Appeal Decision

Appeal Ref: APP/R5510/W/17/3190345

2 Worcester Road, Uxbridge UB8 3TH

- The appeal is made under section 78 of the Town and Country Planning Act 1990 against a refusal to grant planning permission.
 - The appeal is made by Mr P Shanahan (Greystoke Builders Limited) against the decision of the Council of the London Borough of Hillingdon.
 - The application Ref 35129/APP/2017/2264, dated 21 June 2017, was refused by notice dated 16 November 2017.
 - The development proposed is a new dwelling at side.
-

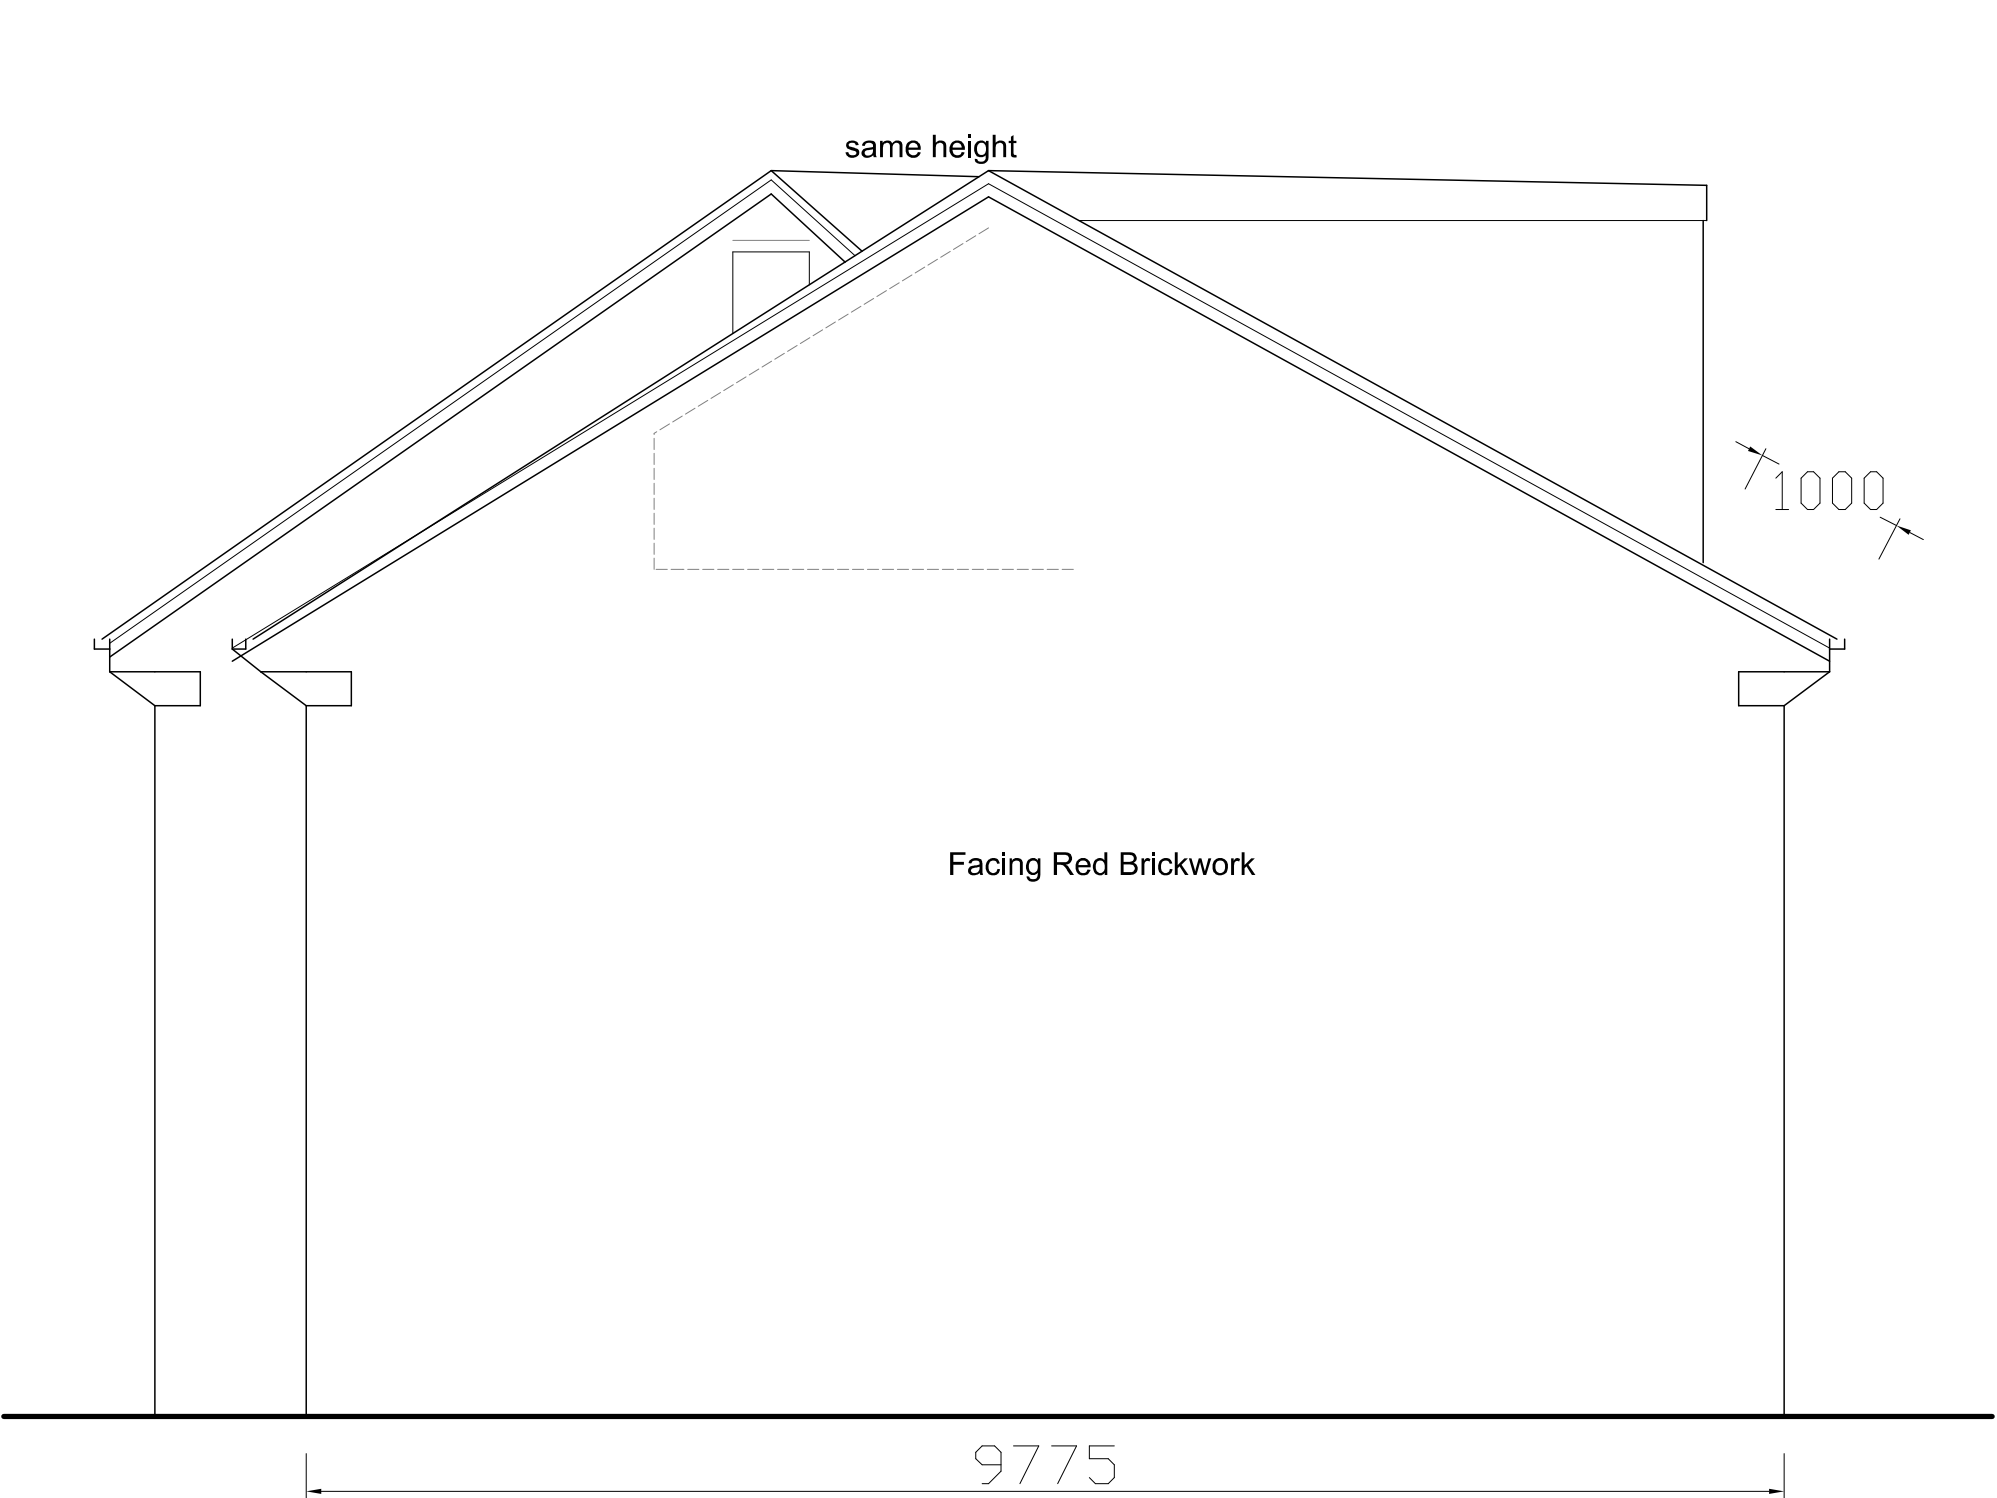
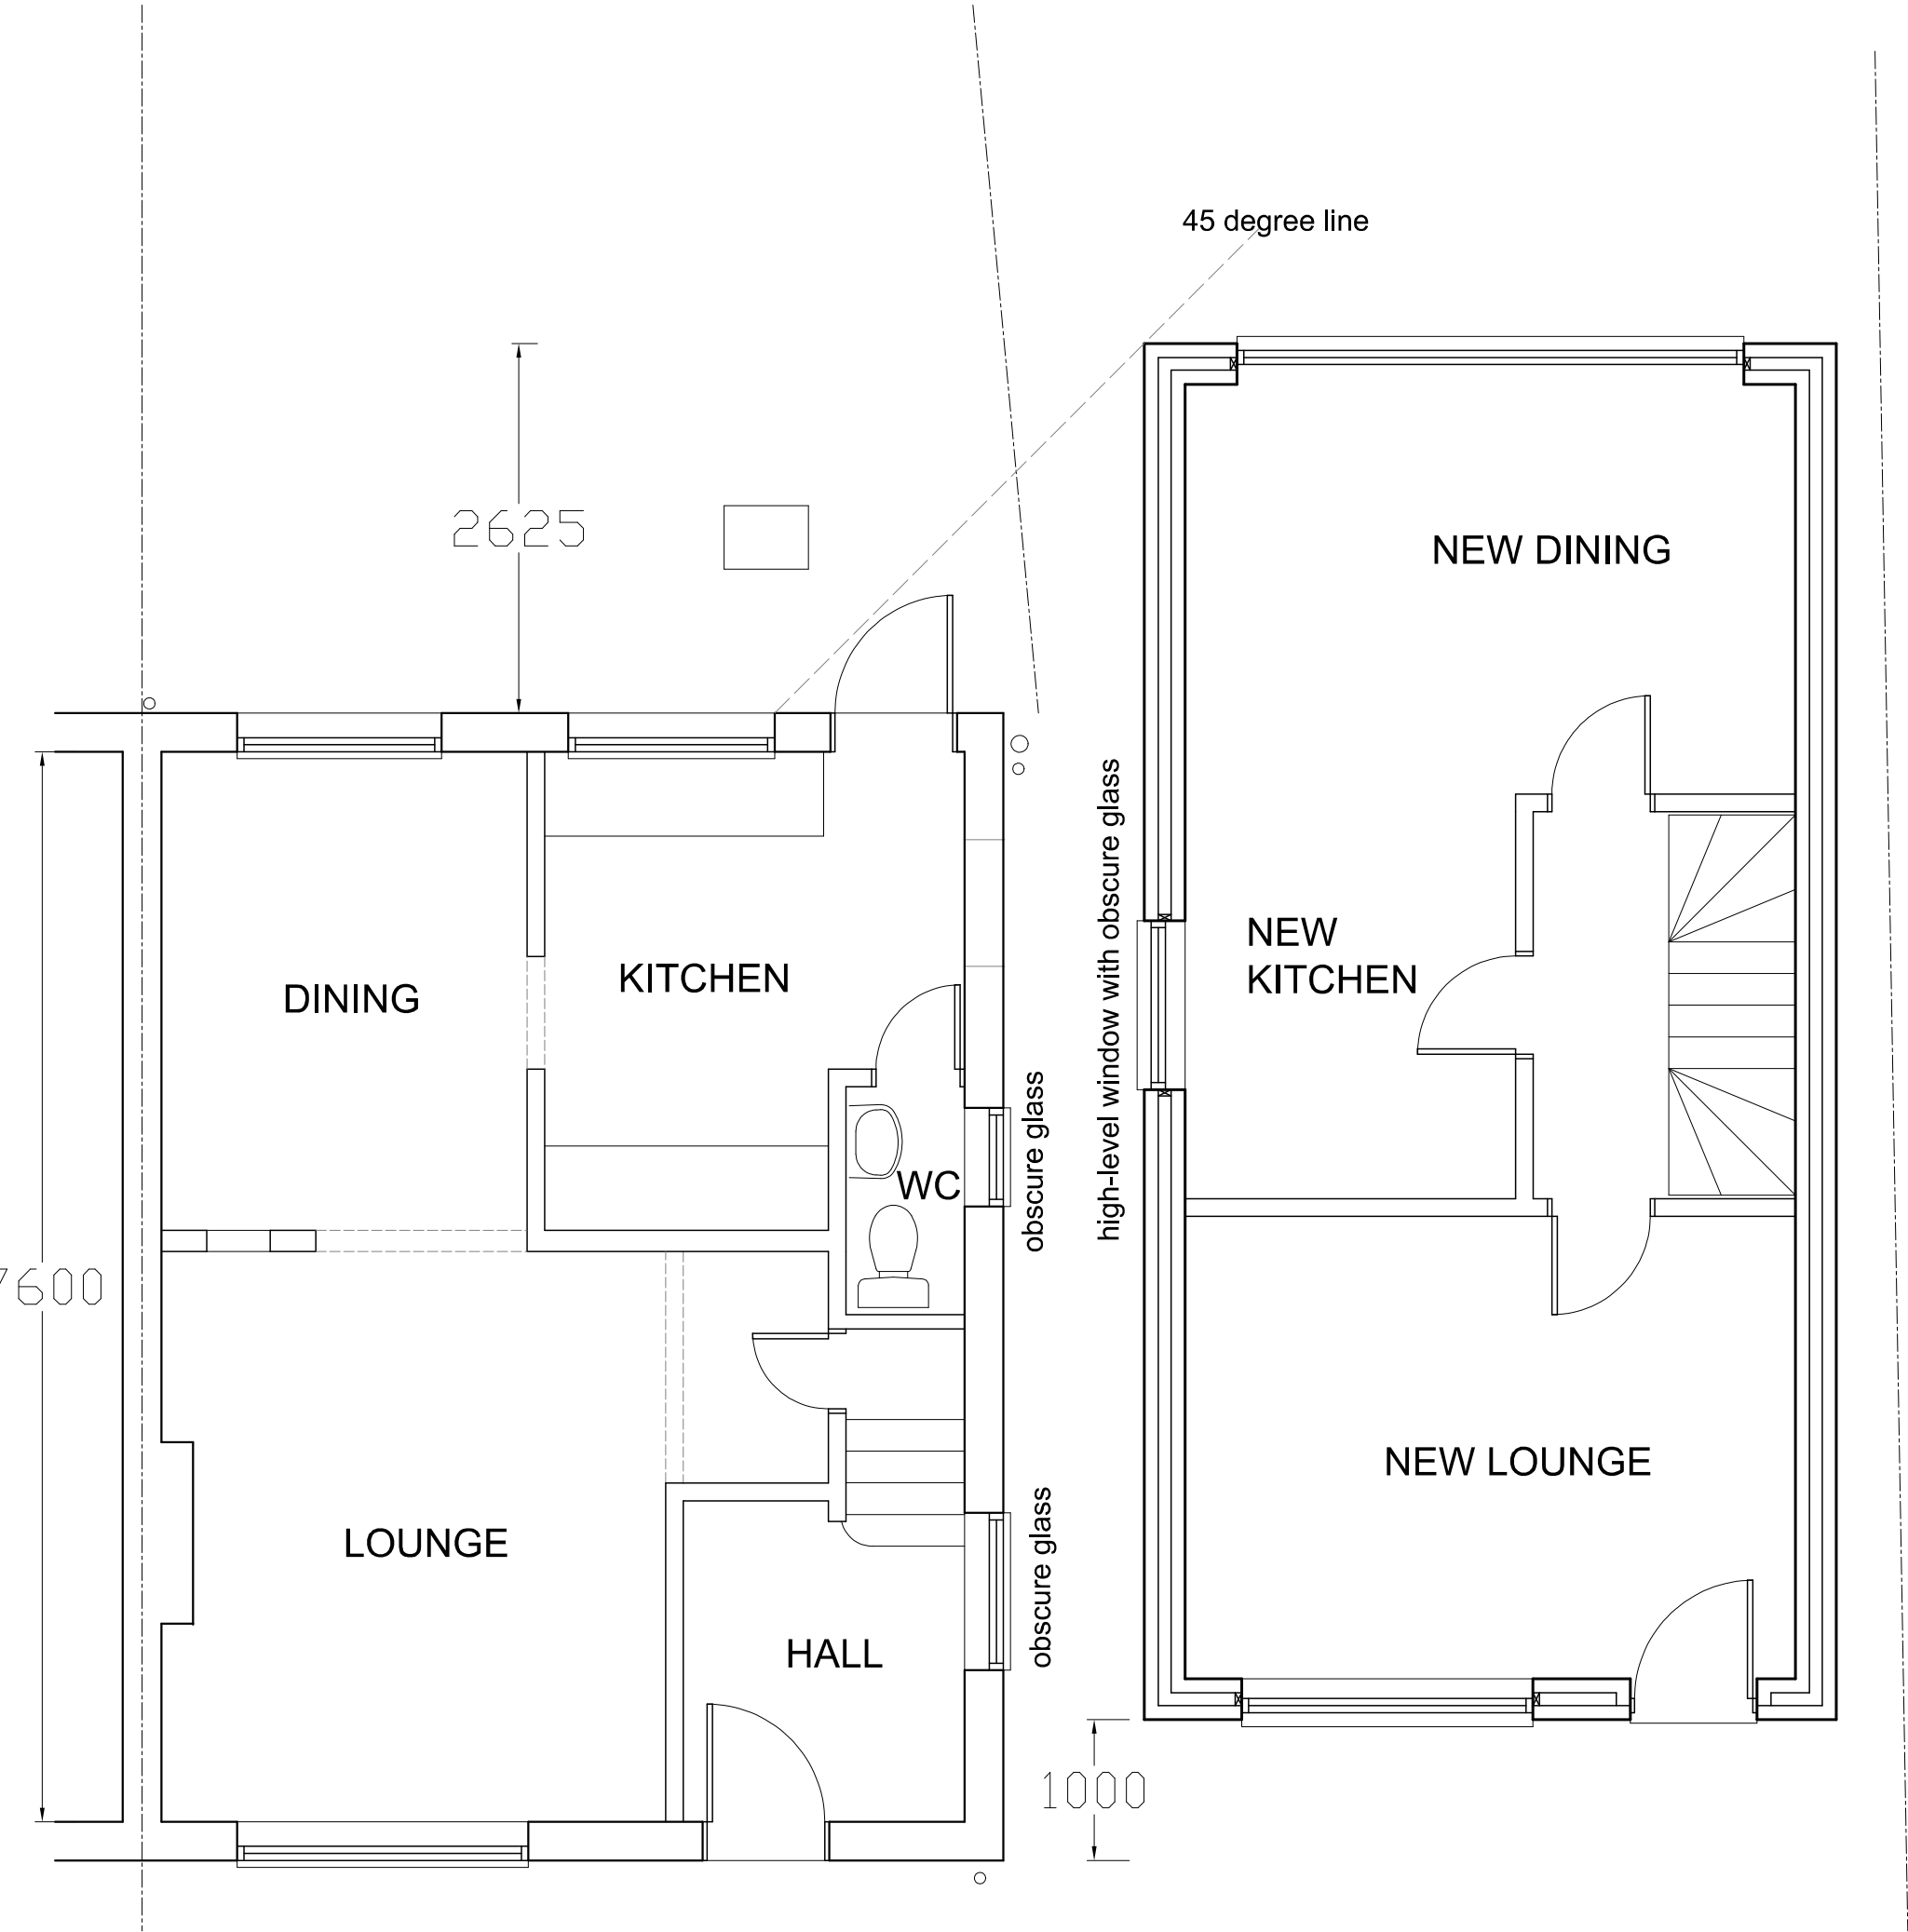
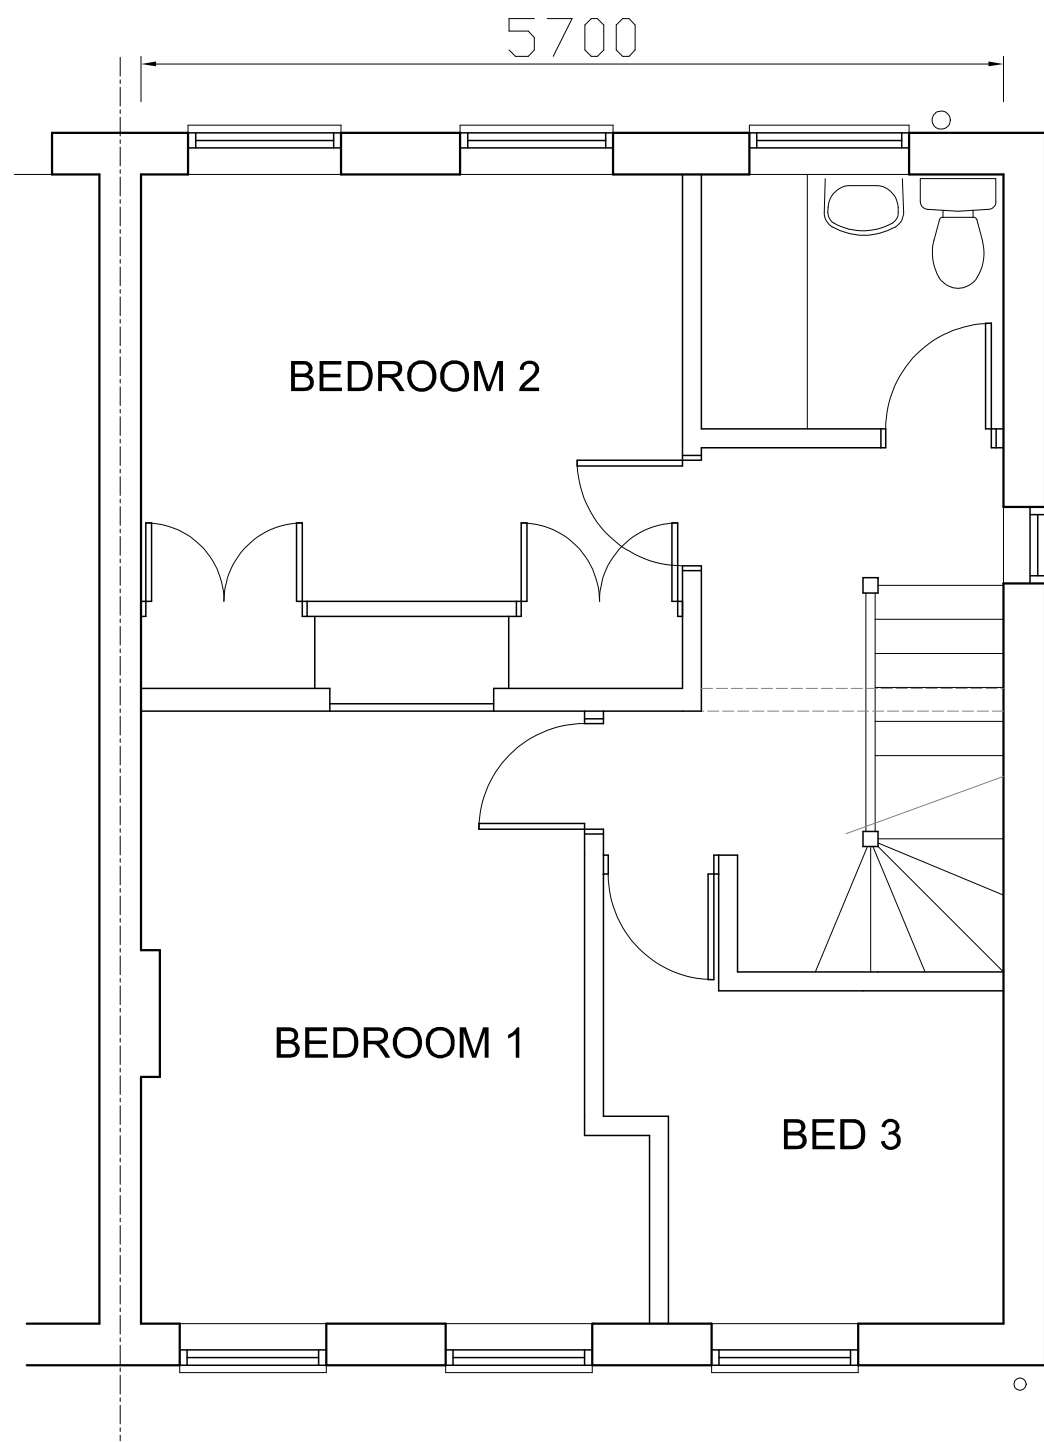
5. The proposed dwelling would also be set back from the front of No. 2, albeit not to the extent of the existing elements at the side of the host property. At the rear, it would extend beyond the rear of No. 2 and, whilst it would present

a longer flank elevation in a prominent position at the entrance to Worcester Road than that of the existing property, it would not be particularly noticeable or harmful.

7. Significantly however, the proposed dwelling's proportions would also fail to reflect the prevailing character and appearance of those of other properties within the street. Whilst it would reflect the heights of ground and first floor levels, and heights to eaves and ridge levels, of the adjacent pair of semi-detached dwellings, its width would be less than that of each half of that pair of semis. As a consequence, its width would appear somewhat compressed and its vertical proportions would overpower the horizontal. This would emphasise its limited width in comparison to the prevailing semi-detached and short terraced rows of houses and make it an incongruous feature at the entrance to the street.

8. Although the site of the proposed dwelling is largely occupied by a single storey garage and playroom extension to the side of No. 2, its overall scale, and particularly its height, is modest and it does not erode the regularity of spacing that I saw to be a consistent feature between properties along Worcester Road and Maygoods Green. In stark contrast however, the detached nature and form of the proposed dwelling, together with the limited spacing around and between it and No. 2, would sit uncomfortably with the relatively spacious, regular spacing between dwellings elsewhere along the street.

10. Although I do not find the flank elevation of the proposed dwelling to be particularly harmful, this does not overcome the concerns I have in other respects. Thus, I conclude that the proposal would fail to harmonise with the scale, form, proportions, character and appearance of other properties within Worcester Road and Maygoods Green. The proposal is therefore contrary to policy BE1 of the Hillingdon Local Plan: Part One – Strategic Policies (LP1), policies BE13, BE15 and BE19 of the Hillingdon Local Plan: Part Two – Saved UDP policies (LP2) and London Plan policies 3.5 and 7.4.
